Modification Report No.5

Tweed Valley Hospital SSD-10353: Changes to Multi-deck Carpark

Project Summary Tweed Valley Hospital – Modification to Stage 2 Consent and Approved Plans

LIFT OVER RUN - LVL 5 / ROOF PLAN
(FIRST CONSTRUCTION STAGE)

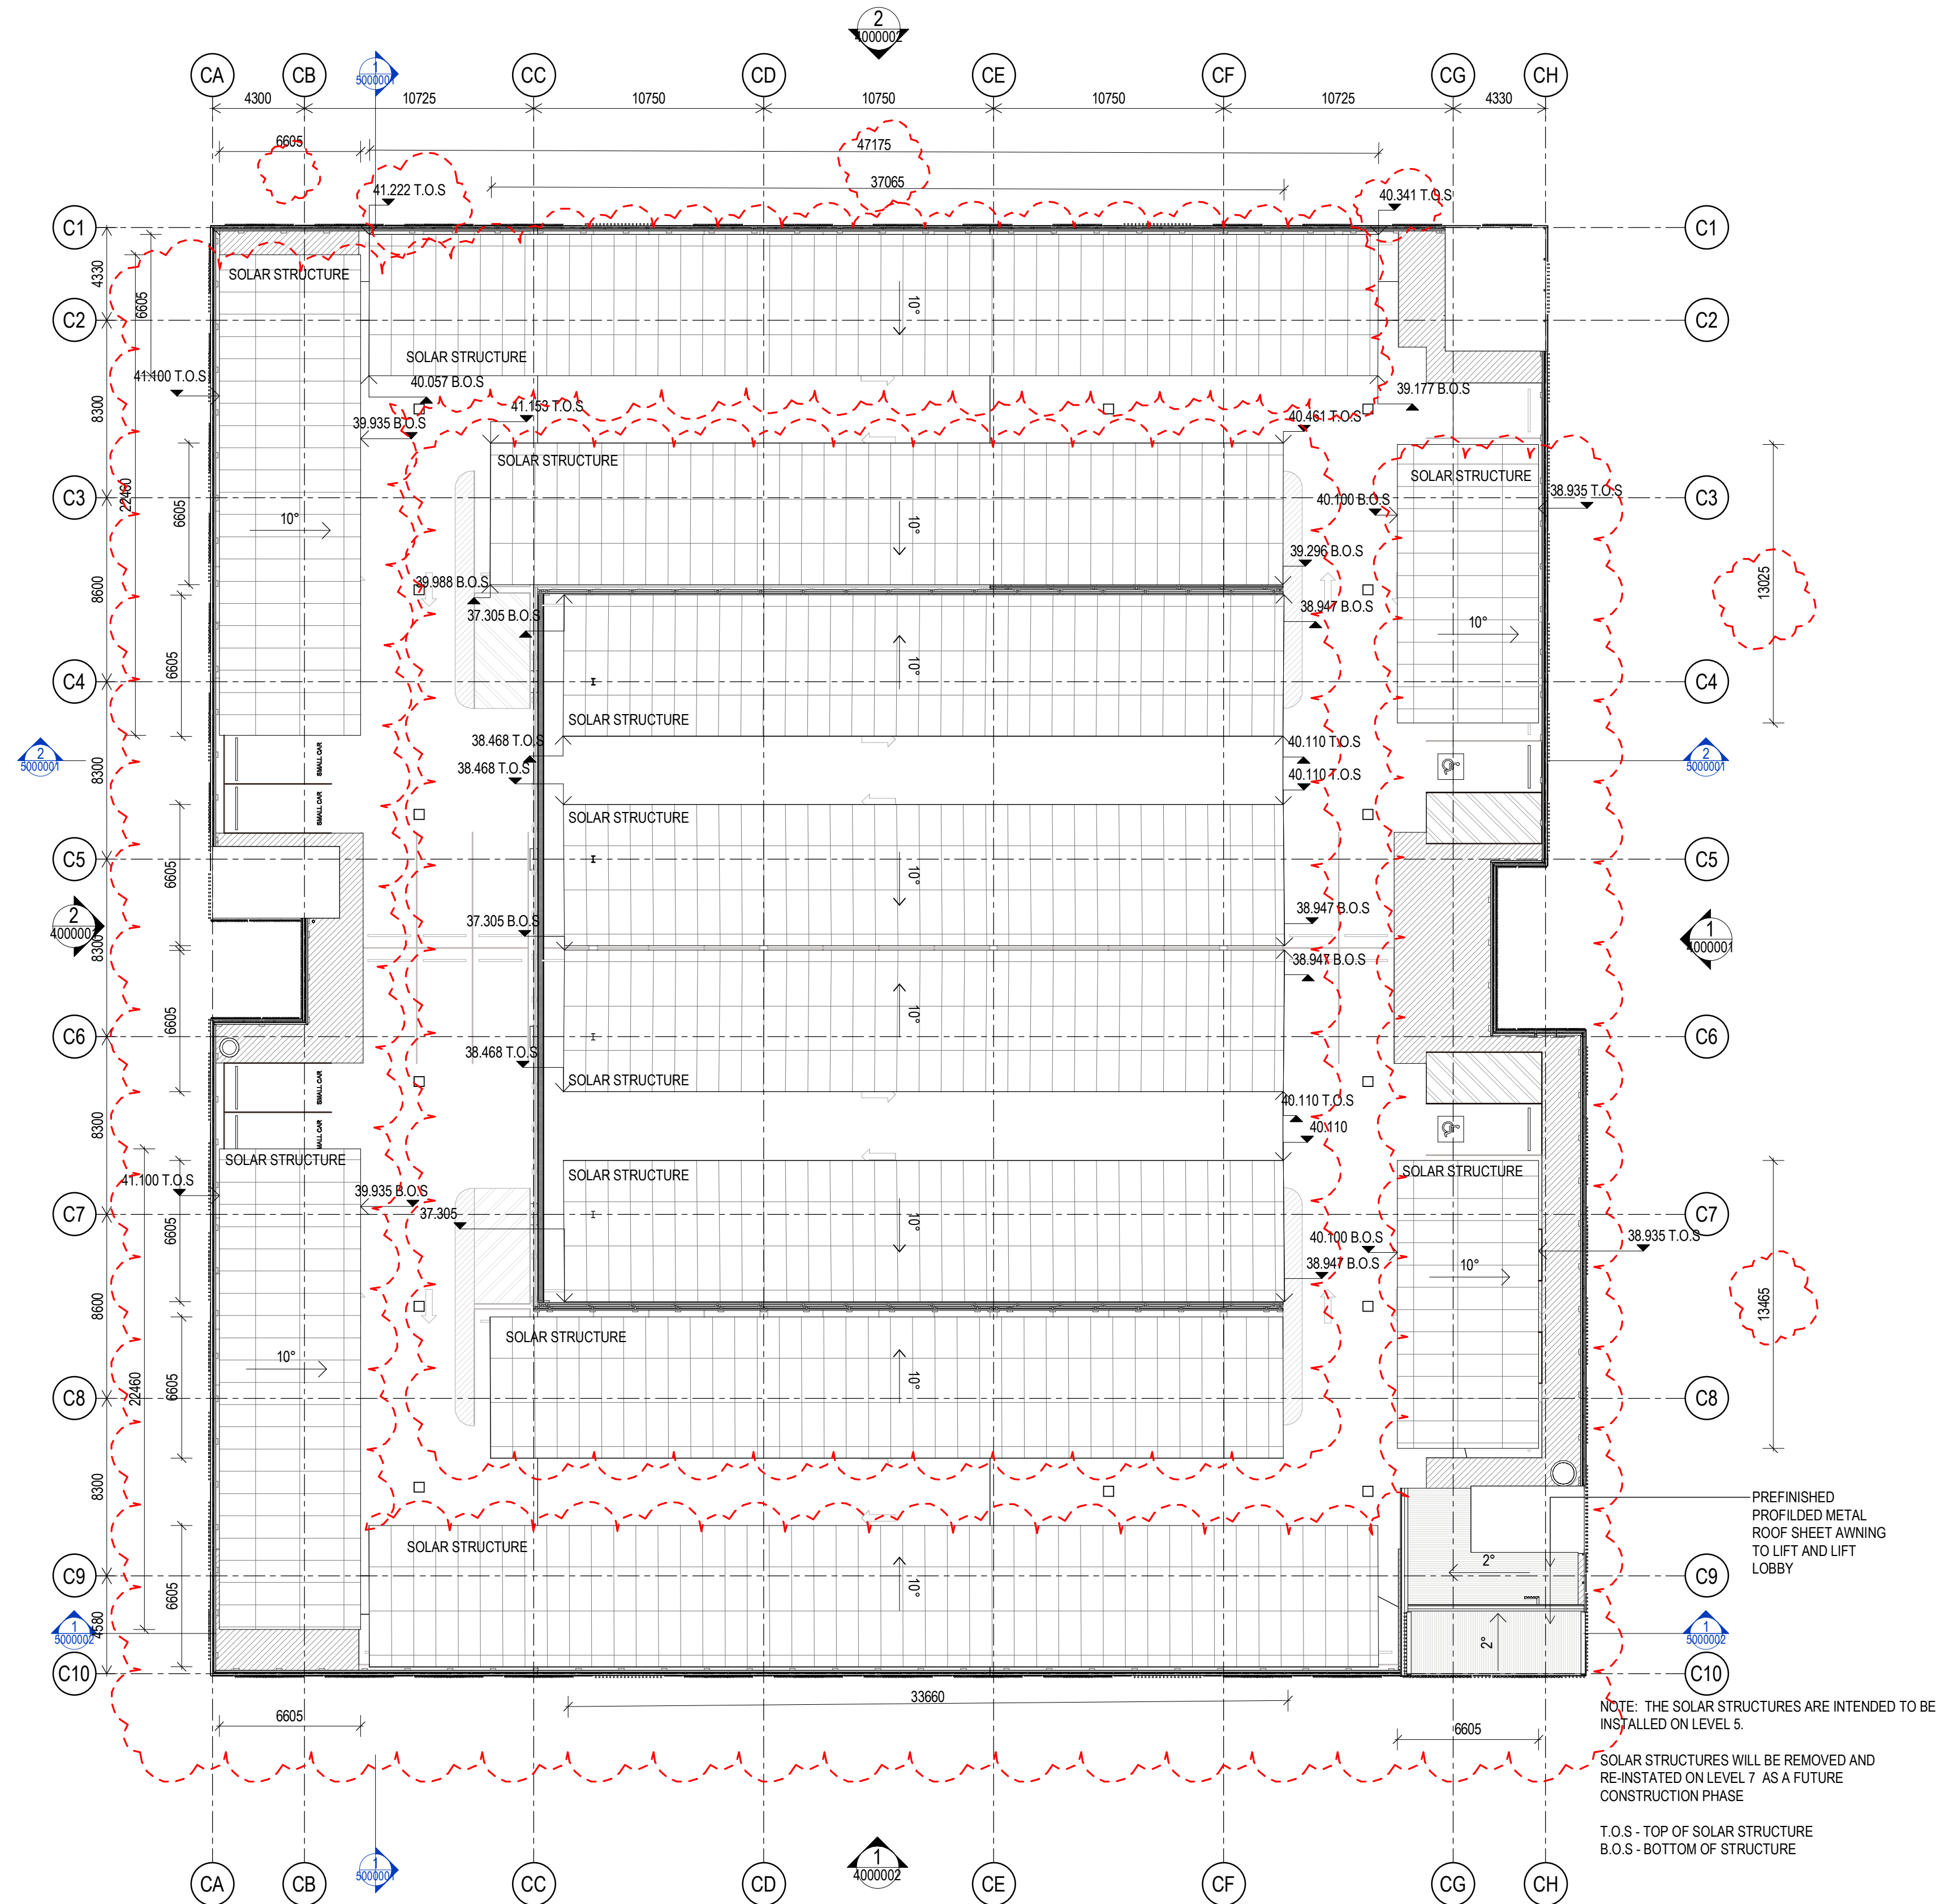
- outdoor exercise equipment rearranged/adjusted.
- roof awning shown to lift lobby (level 5)
 - The nominated lift manufacturer requires a higher clear internal lift overrun dimension. The lift overrun has been amended from RL 46150 to RL 46350 to suit the Vertical Transport Manufacturer Requirements. This still falls within the permissible building envelope approved with the Concept Proposal.

2 ELEVATION SOUTH
Scale: 1:200

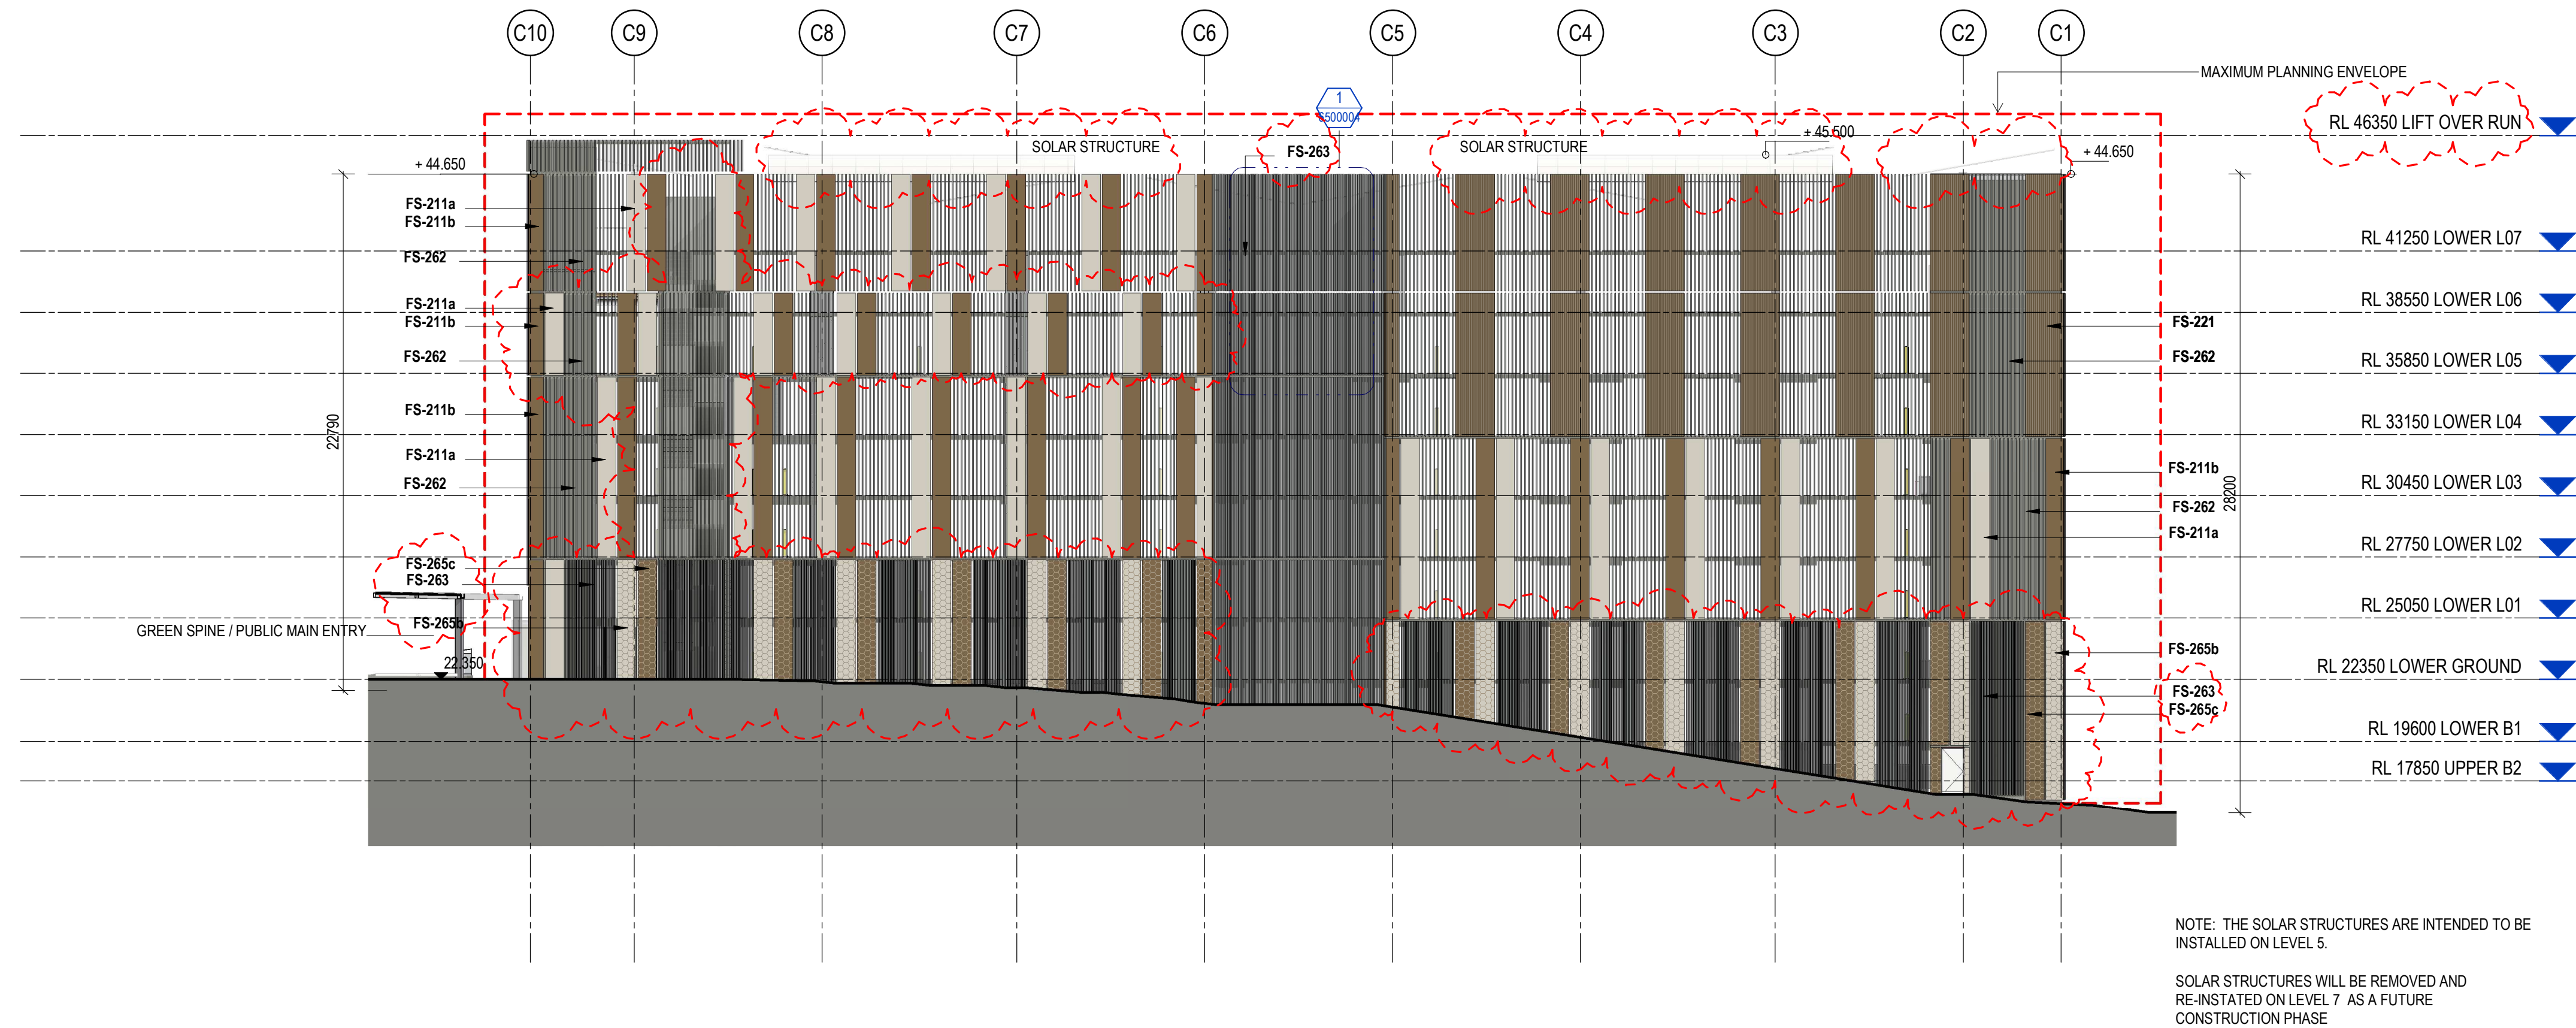
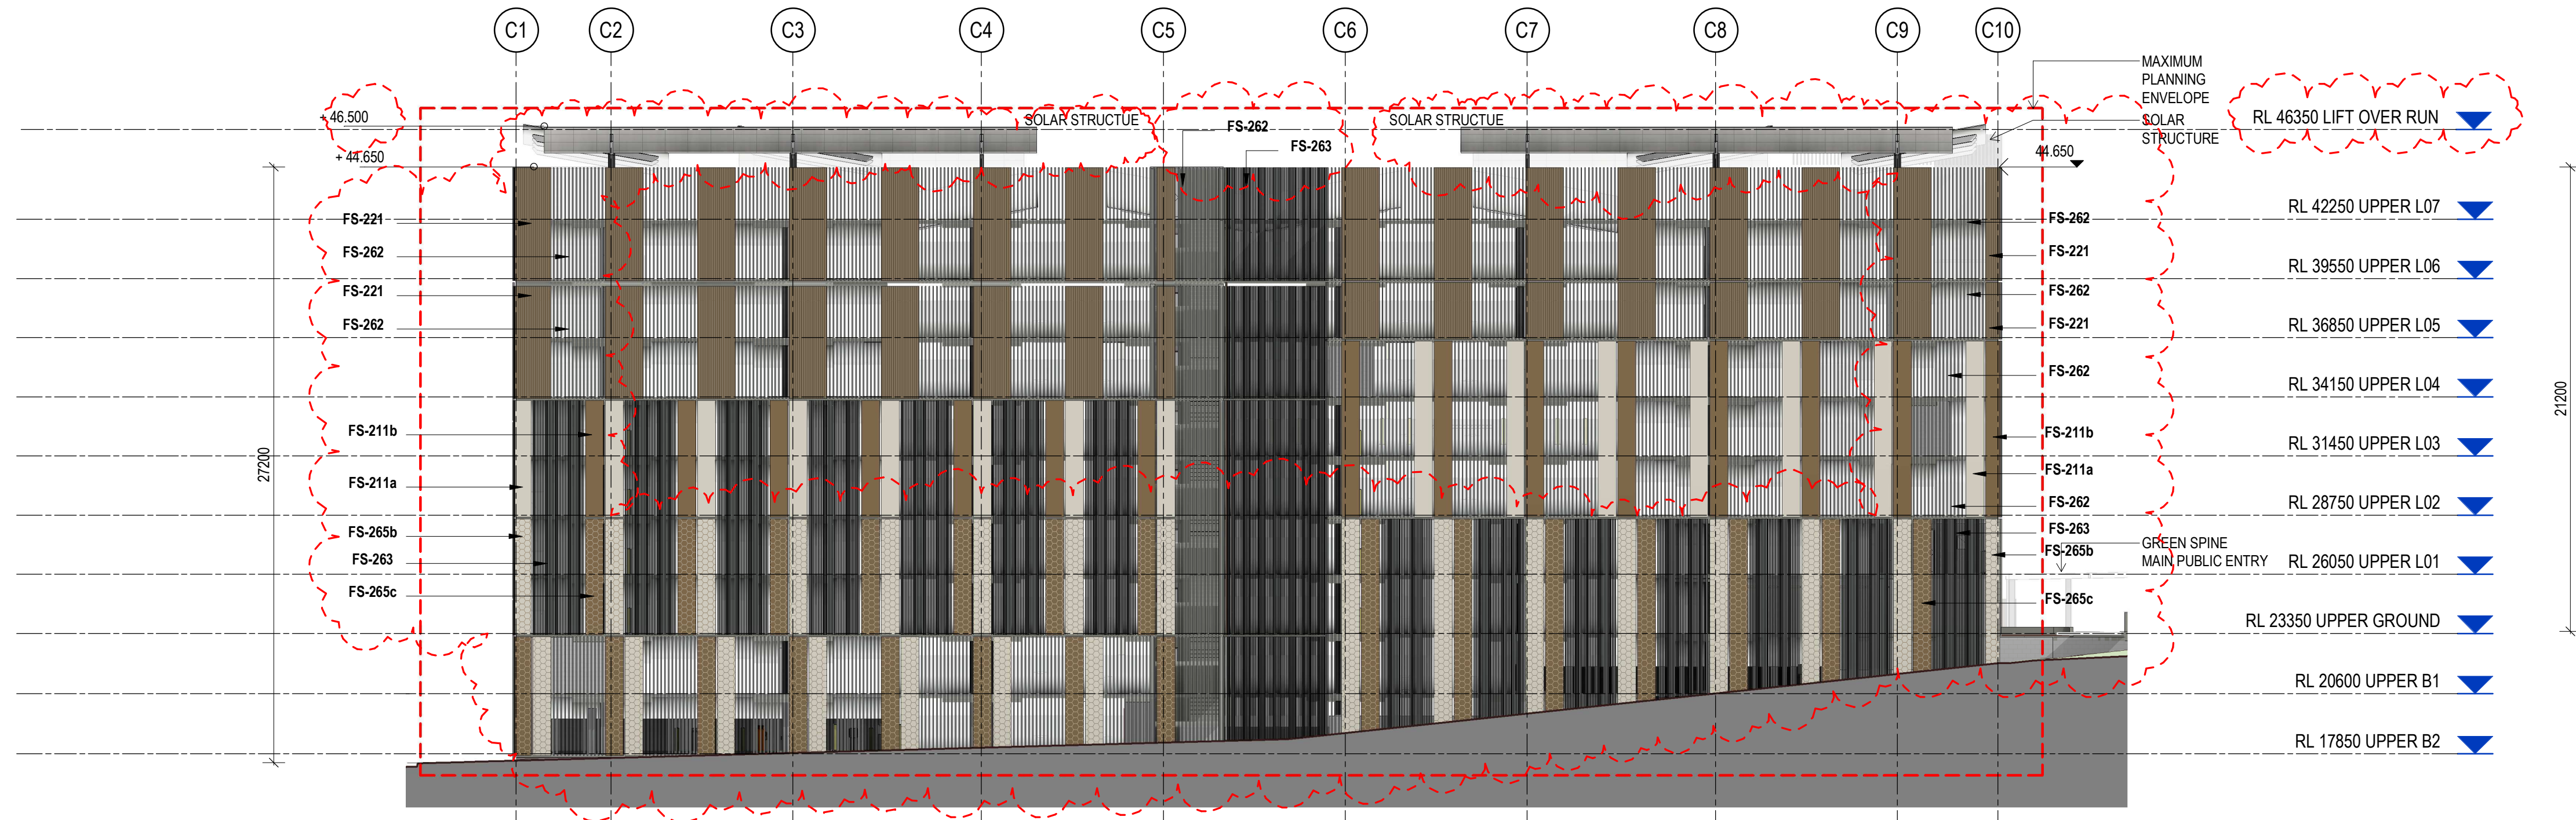
Subsequent to approval of Mod 3 comprising a revised façade material treatment, during consultation, Fire and Rescue NSW (FRNSW) noted that “the performance solution is heavily reliant on the natural ventilation provided by the open-deck nature of the aboveground levels of the carpark. Given that this natural ventilation is to be relied upon, the assessment is to quantitatively demonstrate that this will provide/maintain tenable conditions such that safe occupant egress provisions are provided at all times given a worst-case credible fire scenario.”

In order to support the extended travel distances, and satisfy the concern raised by FRNSW, the project has been required to increase the percentage open air above the minimum requirement noted in the Building Code of Australia (BCA) to 60% unobstructed airflow plus an additional safety factor. This safety factor exists to mitigate any likelihood that the façade would fall below the threshold of the BCA should the open area of the façade become obstructed in the future and in turn non-compliant

To achieve the required unobstructed percentage as per the Fire Engineering Brief Consultation Questionnaire (FEBQ) the façade panels need to have perforations of 73% Open on the Ground Floor and Level 1, and 55% for Levels 2 to 5 respectively. The perforation hole types have also been revised to achieve this perforation level and maintain structural integrity.

Figure 3.1 and **Figure 3.2** provide a sample comparison of the approved and modified southern elevations of the multi-deck carpark, demonstrating a strong similarity.
